DELEGATED REPORT

Application Number: 21/00068/FUL

Proposal: Conversion of garage to habitable space and alteration from 1no. garage door to 1no. window. Erection of a front porch. Erection of a single storey rear extension and formation of covered terrace. Removal of 1no.window to side elevation (amended description)

Site Address: 12 Sunderland Avenue Oxford OX2 8DX

Proposed Ground Floor Plan

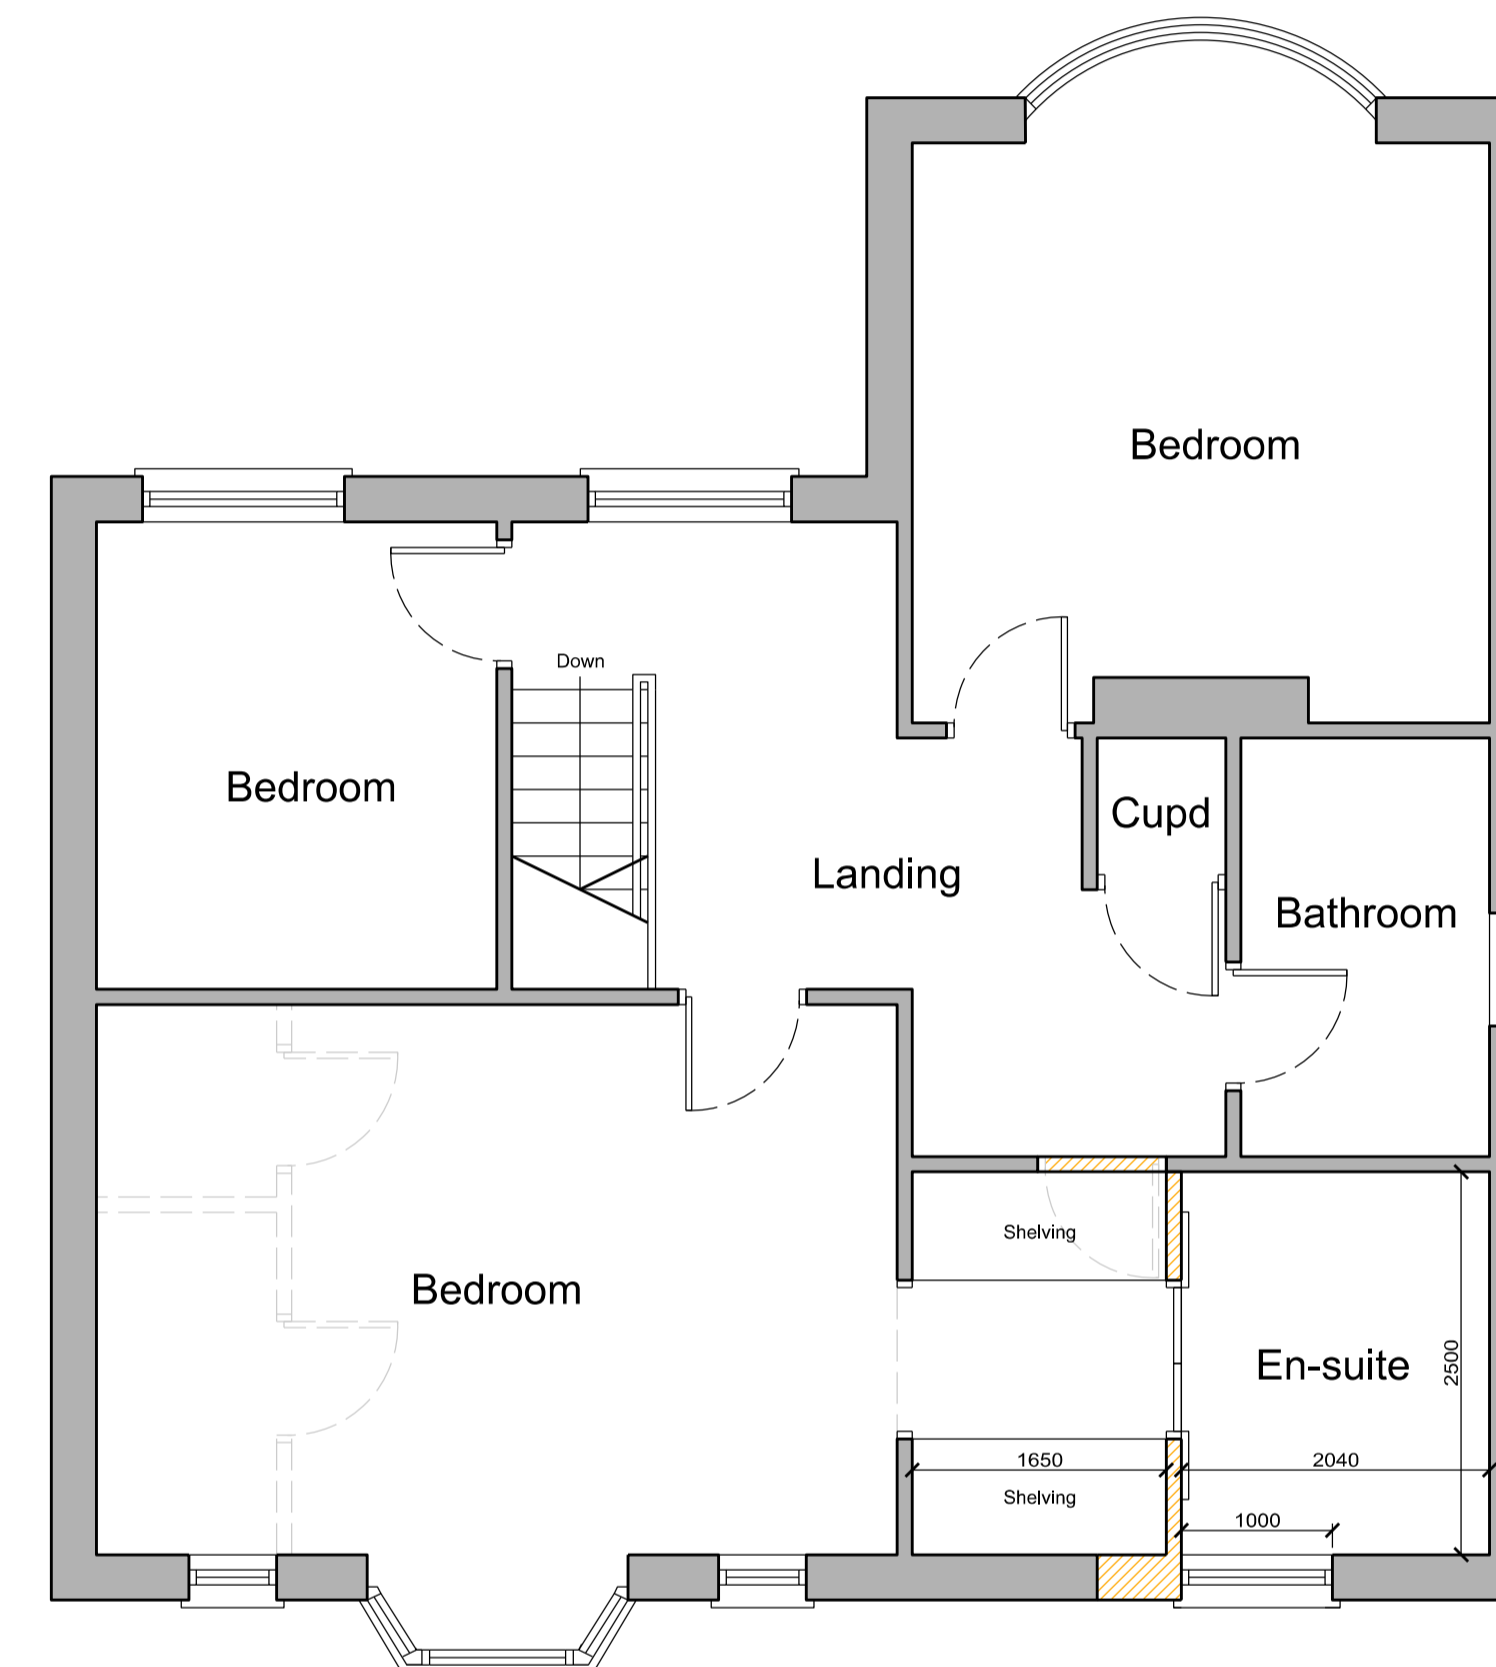
Planning permission is sought for the conversion of the garage into a habitable space providing a utility and shower room. It is also proposed to erect a front porch that would extend beyond the principal elevation by approximately 2.8m, have a

width of 2.95m and be constructed under a pitched roof with an eave height of 2.4m and a ridge height of 3.6m. To the rear of the property it is proposed to erect a single storey rear extension that would extend beyond the rear elevation by 5m and have a width of 4.4m. It would be constructed under a flat roof with a height of 2.95m. Also to the rear of the property, it is proposed to erect a covered terrace. The roof covering would be at a height of 2.8m and would be connected to the rear elevation of the existing house and to the side elevation of the proposed extension. It would be supported by 2no. vertical beams.

The proposed garage conversion would not result in any adverse residential amenity impacts as the majority of the alterations are internal, excluding the new window to the front elevation. This proposed window would have no impact on the residential amenity of the neighbouring properties and would not give rise to any breaches or privacy as it does not provide direct views into neighbouring gardens or habitable rooms.

Proposed Front Elevation

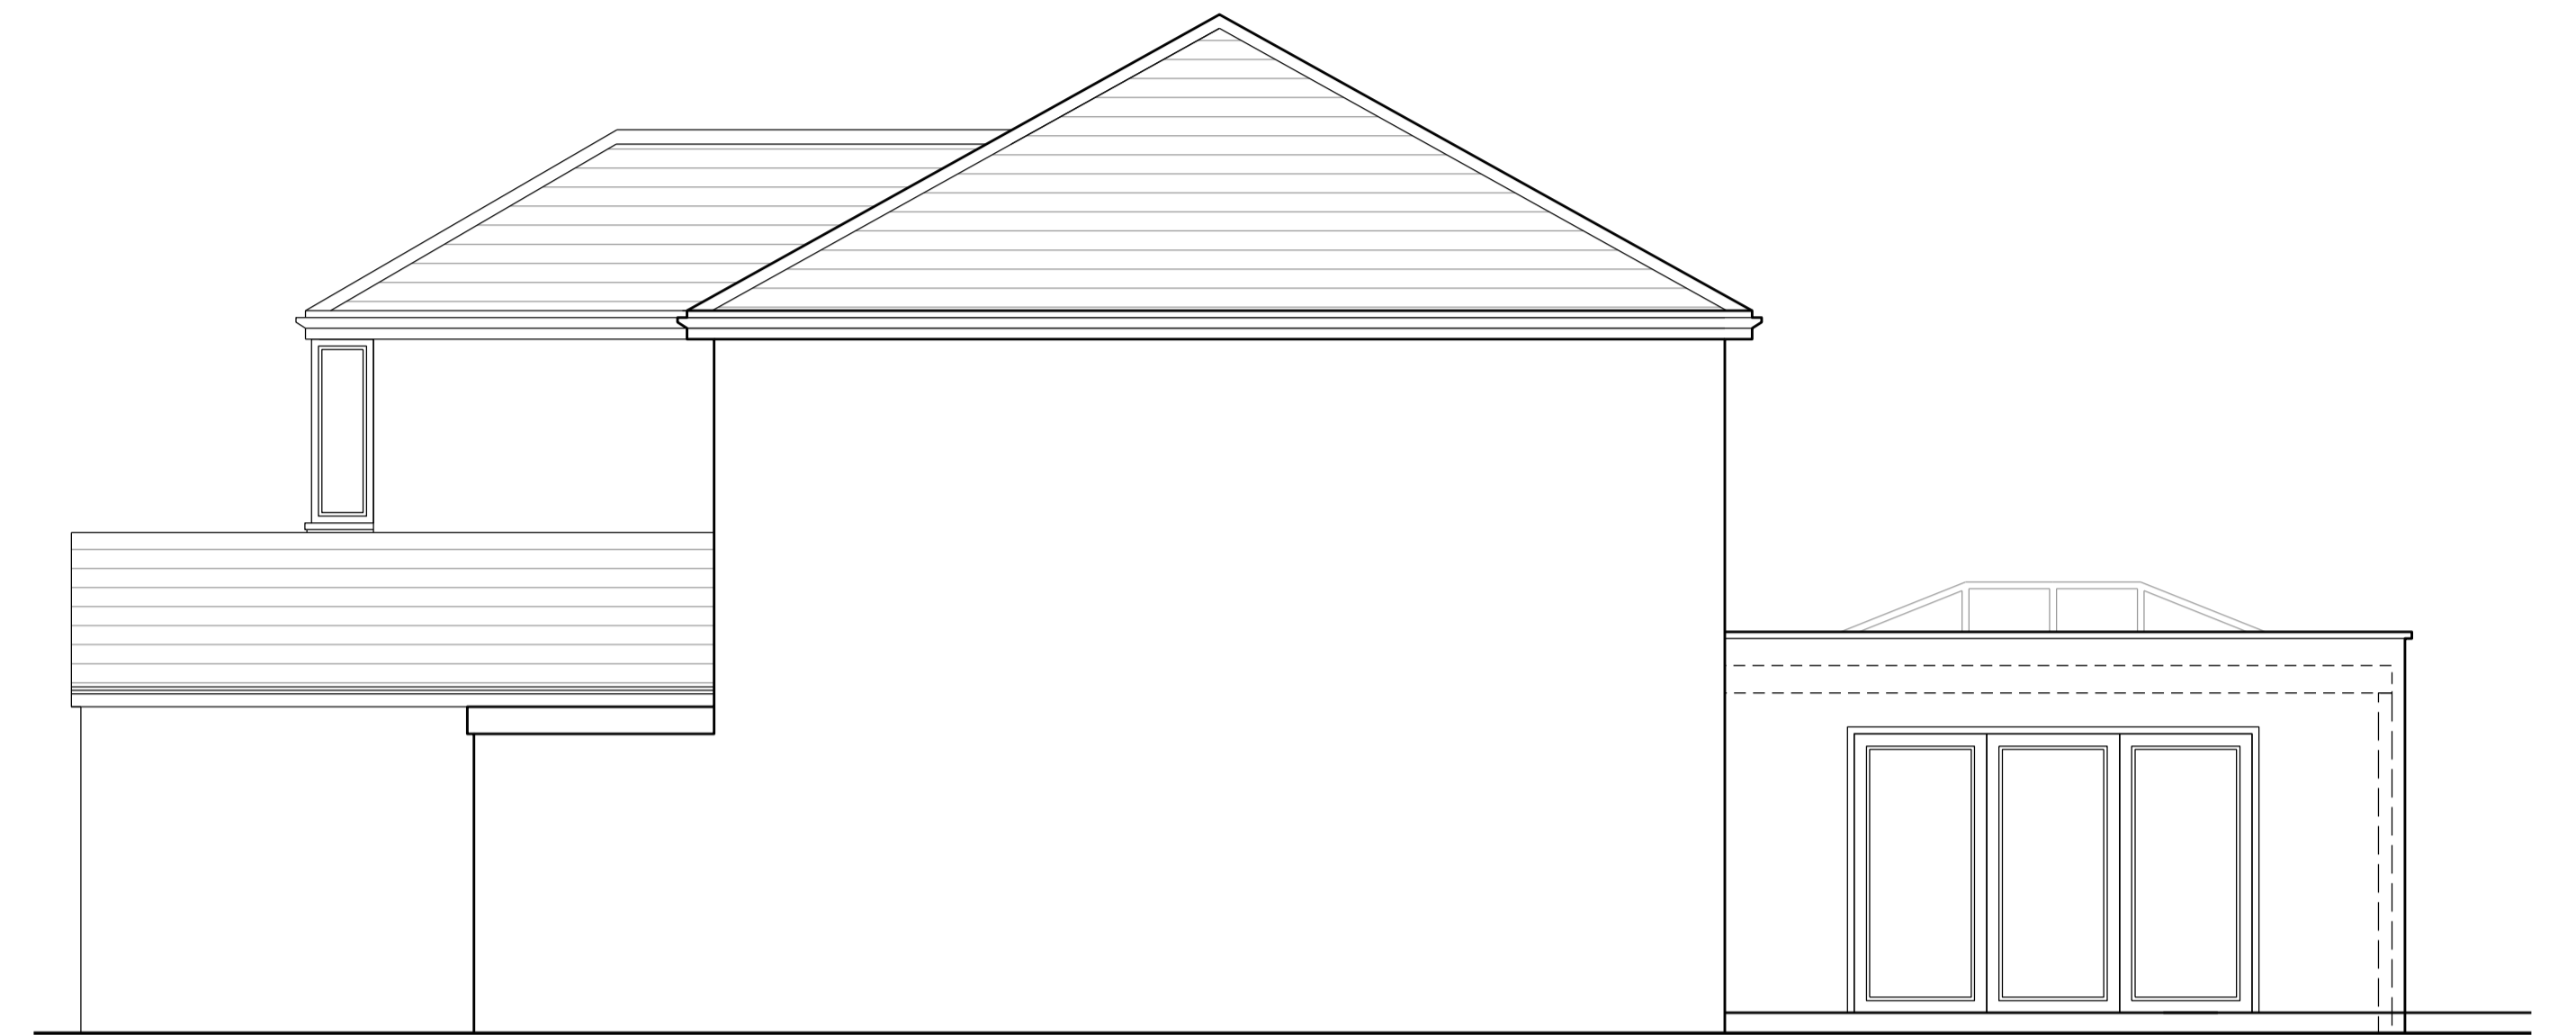
Although the porch would be in excess of permitted development in terms of height and ground cover, due to its location within the plot, and the set-back nature of the house from the highway, officers are satisfied that the porch would not have an adverse effect upon the street scene. There are a variety of different porch designs with flat and pitched roofs, therefore this design would not be out of character with the area, and the proposed materials would match the existing as to ensure it would appear as a congruent addition to the host property.

The conversion of the garage to a habitable space primarily consists of internal alterations and would therefore have no design impact on the street scene. The proposed door to window alteration would be visible from the street scene. However, given that the new window matches the design of the existing fenestration, in addition to the set-back nature of the property from the highway, officers are satisfied that the proposed new window would be acceptable in design terms and form an appropriate visual relationship with the existing fenestration.

The proposed porch would pass the 45/25 degree access to light test, outlined in Policy H14. Therefore, the porch would not impinge on the daylight received by either neighbour. Although the porch would be in excess of permitted development in terms of height and ground cover, due to the location of the porch within the plot, in addition to how set-back the property is from the highway, officers are satisfied that it would not result in any unacceptable overbearing or enclosure impacts to either neighbour. Nor would it give rise to any breaches or privacy.

Proposed Rear Elevation

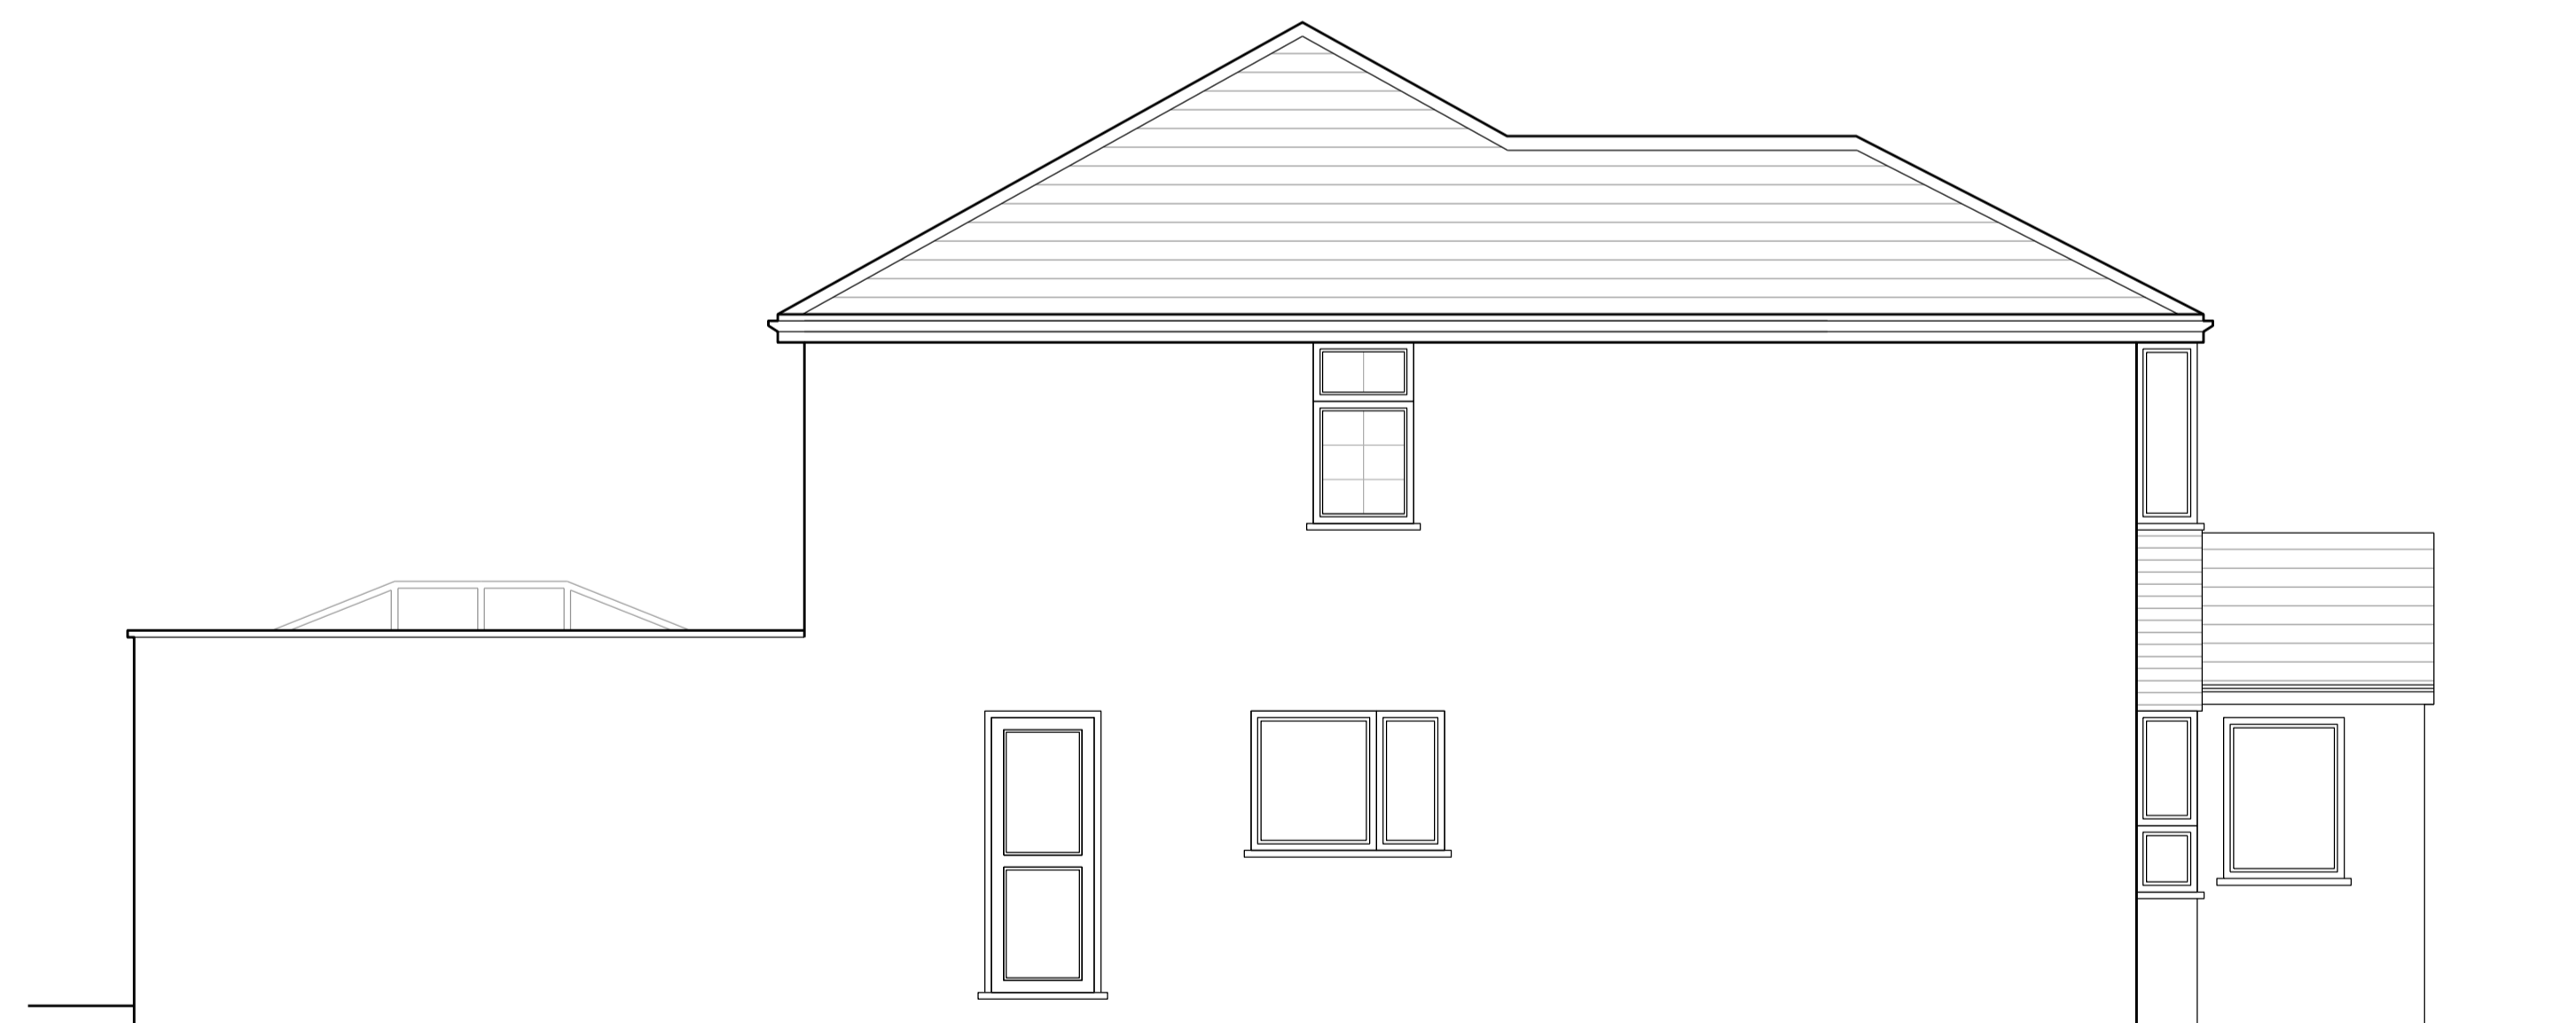
There are a variety of property types of different shapes and sizes and rear extensions are common in the area. Although the extension would be relatively deep at 5m, given the size of the existing house and plot, it is considered that the extension would be a proportionate addition to the host dwelling. Due to the large area of glazing to the rear elevation, the extension would clearly read as a contemporary addition and would not compete with the host property in terms of form, size or use. Through the use of materials to match the existing property, the extension would represent a congruent addition to the host dwelling.

The covered terrace is a lightweight structure that would cover the area between the side elevation of the proposed rear extension and the rear elevation of the dwelling and would be supported by 2no. vertical beams. Although there are no similar examples in the surrounding area, officers are satisfied that due to its lightweight structure the design would not be harmful. In addition, as it would only be visible to limited private views and that the application site is not in a conservation area, officers are satisfied that it would not harmfully impact the character of the surrounding area.

The proposed rear extension would also pass the 45/25 degree access to light test. Therefore, the extension would not impinge on the daylight received by either neighbouring property. As the extension is set off the common boundary with No.14 by approximately 1.6m, and that the extension would only extend beyond the rear elevation of No.14 by approximately 1.5m, officers are satisfied that the extension would not result in any unacceptable overbearing or enclosure impacts to these occupants. Likewise, due to the placement of windows, there would be no breaches of privacy as they do not provide direct views into neighbouring gardens or habitable rooms.

When applying the 45/25 degree access to light test in the vertical plane, the proposed covered terrace would pass this test and would therefore not impinge on the daylight received by the rear ground floor window of No.10. In addition, as it would have a slightly reduced roof height compared with the proposed extension, of 2.8m, and would be set off the common boundary with No.10 by approximately 1.3m, which is approximately 2.5m away from the side elevation of No.10, officers are also satisfied that this structure would not result in any unacceptable overbearing or enclosure impacts to these occupants.
